Mynydd y Gwynt Windfarm

Planning Inspectorate EN: 10020

Natural Resources Wales

Response to ExA's Request for Further  
Information

Title  
TYPICAL CRANE HARD STANDING  
PLAN AND ELEVATION

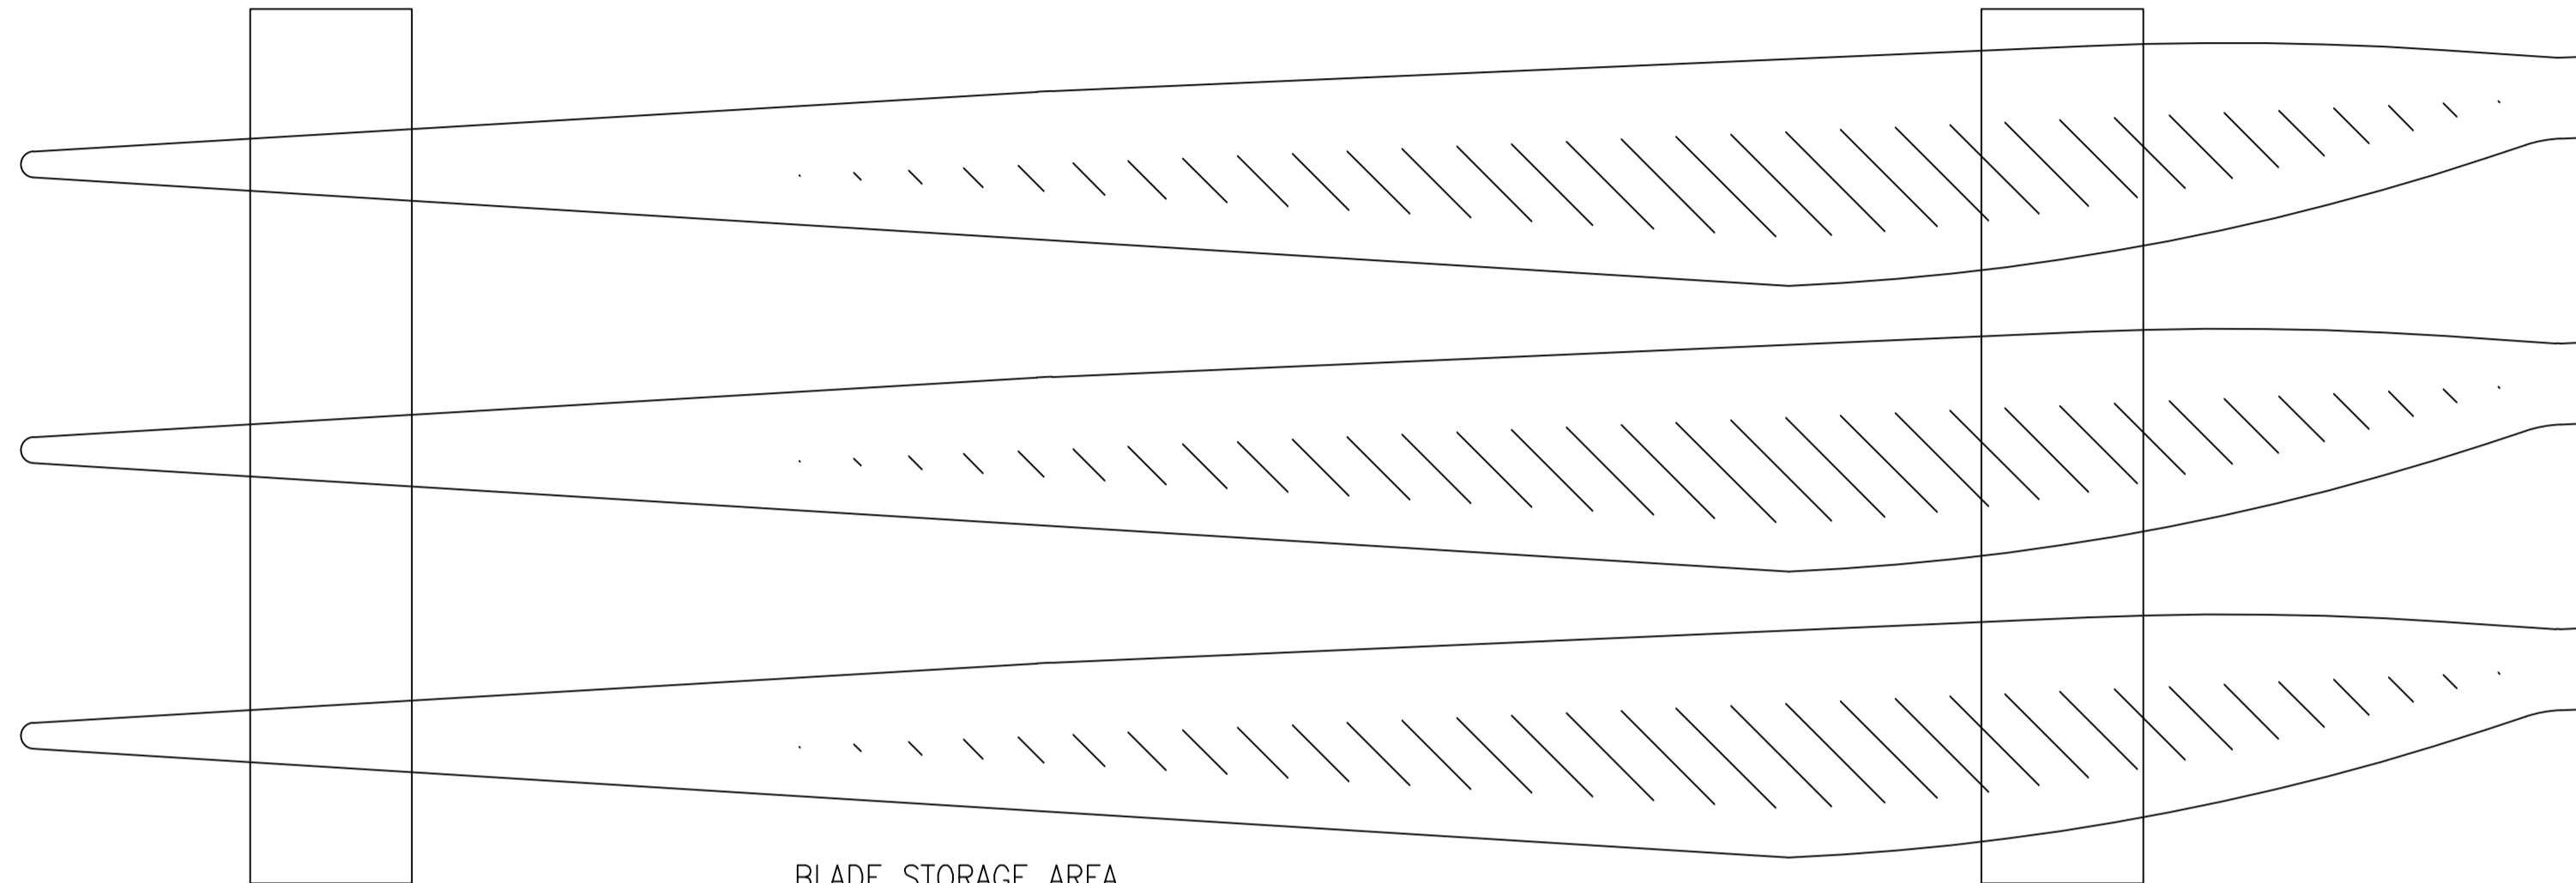
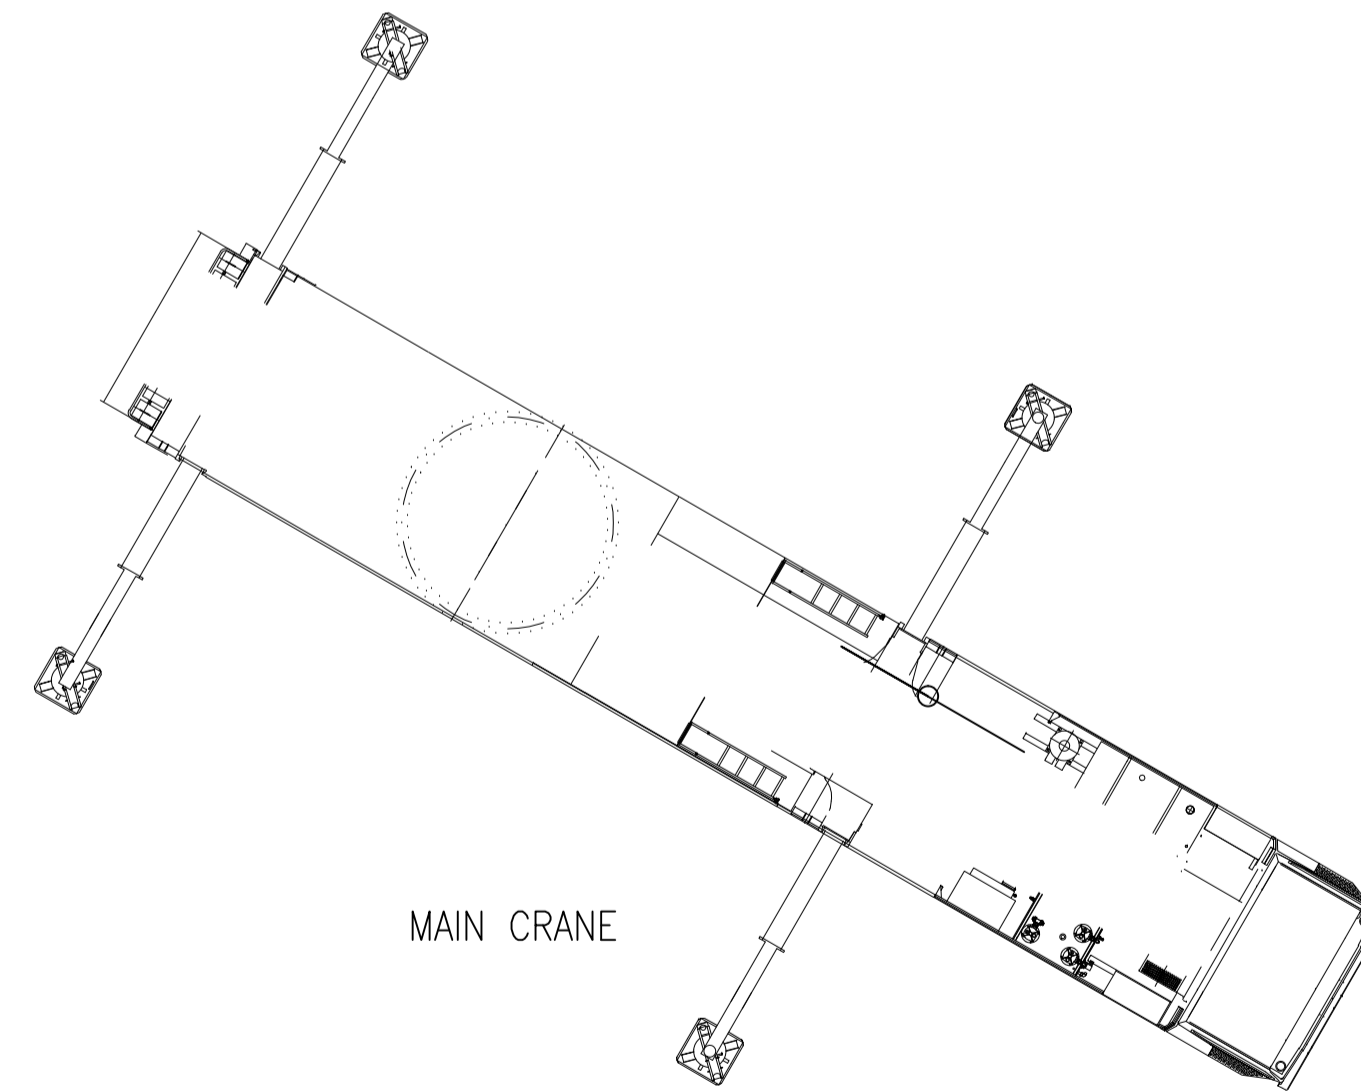
iv) NRW’s concern is to clarify the awkward description of the work so that it is clear that there is an open area of hardstanding on which stands a building and a fence around the hardstanding. NRW has referred to particular plans in the ES showing these works. NRW invites the Applicant to better define its proposal.
